PLANNING AMENDMENT

PLOT 2, CROSS STREET, HOLBEACH.

Proposed bungalow
and detached double
garage

Amendment: Re-position dwelling on Plot 2 (Drawing No. 1321/1A and
1321/3A)

Site Plan

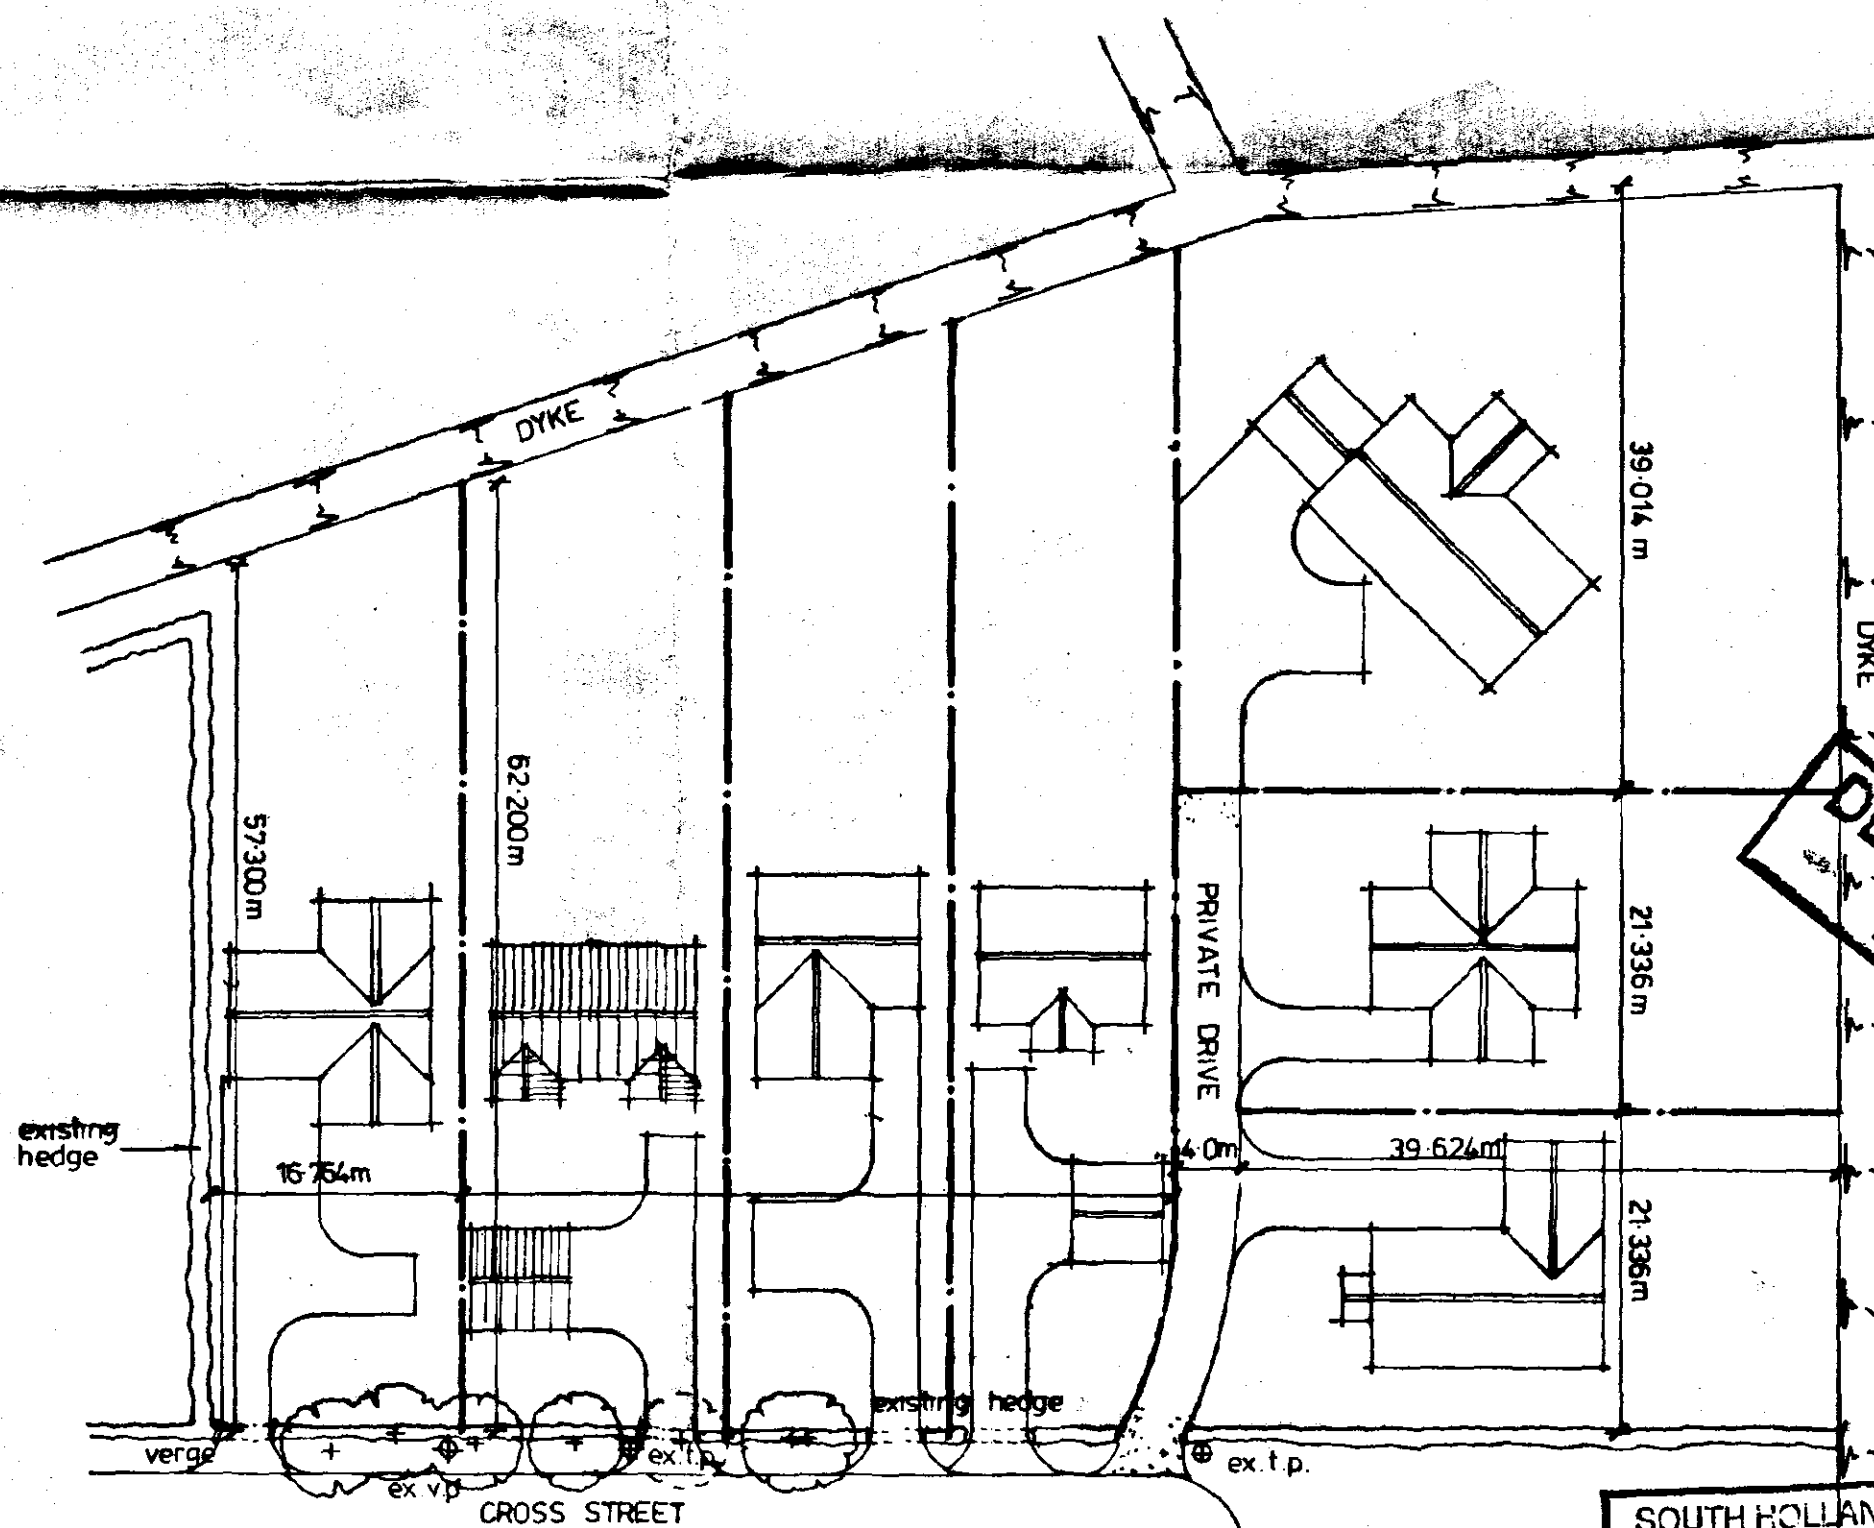
Re-position dwelling on Plot 2.
